Harnett County Government Complex
307 W. Cornelius Harnett Boulevard
Lillington, NC 27546

August 18, 2009

Re: Status of Improvement Permit Application #09-5-22643

PRELIMINARY SITE PLAN FOR:
WYNN CONSTRUCTION

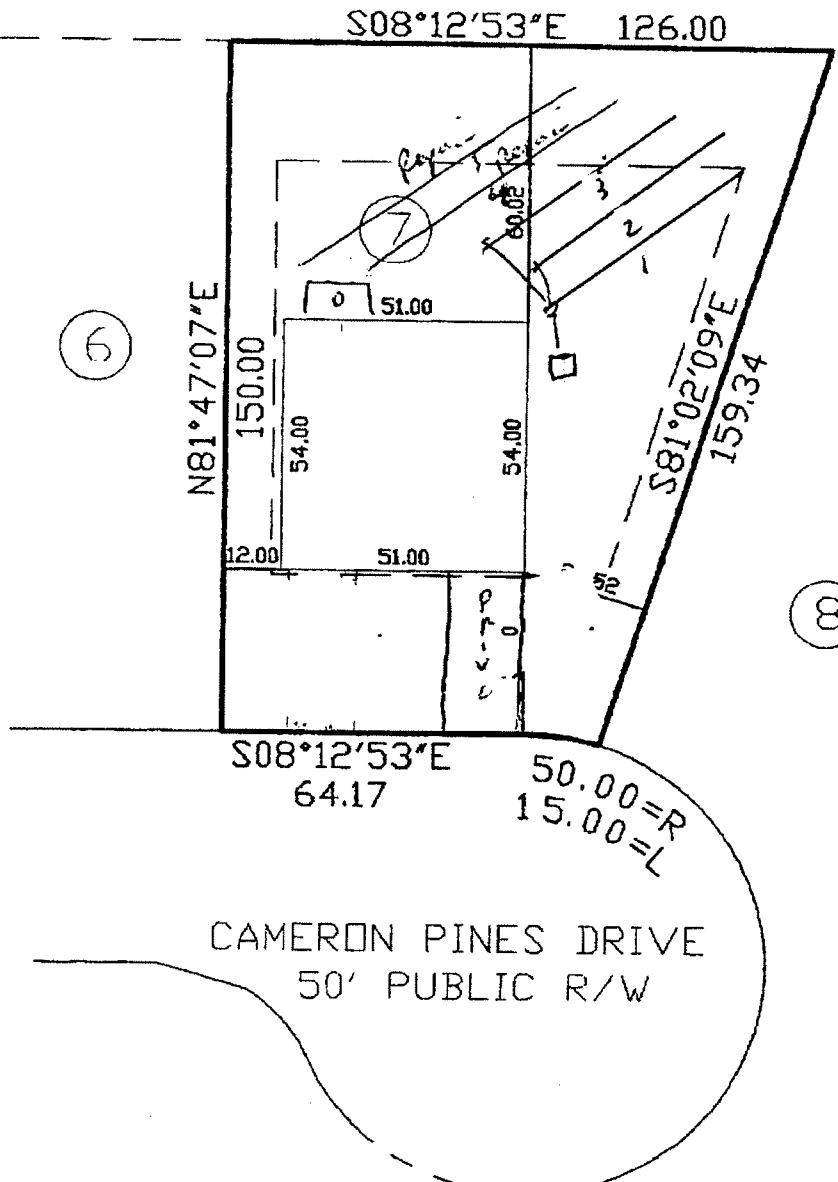
- 1. Property lines/corners not marked or labeled (Irons need to be visible)**
(\$25.00 fee incurred)
- 2. House corners not marked or labeled *(\$25.00 fee incurred)*
- 3. Directions not clear to property *(\$25.00 fee incurred)*
- 4. Property needs brush or vegetation removed
- 5. Backhoe pits required
- 6. Other – Site plan does not match soils consultant’s proposal.**
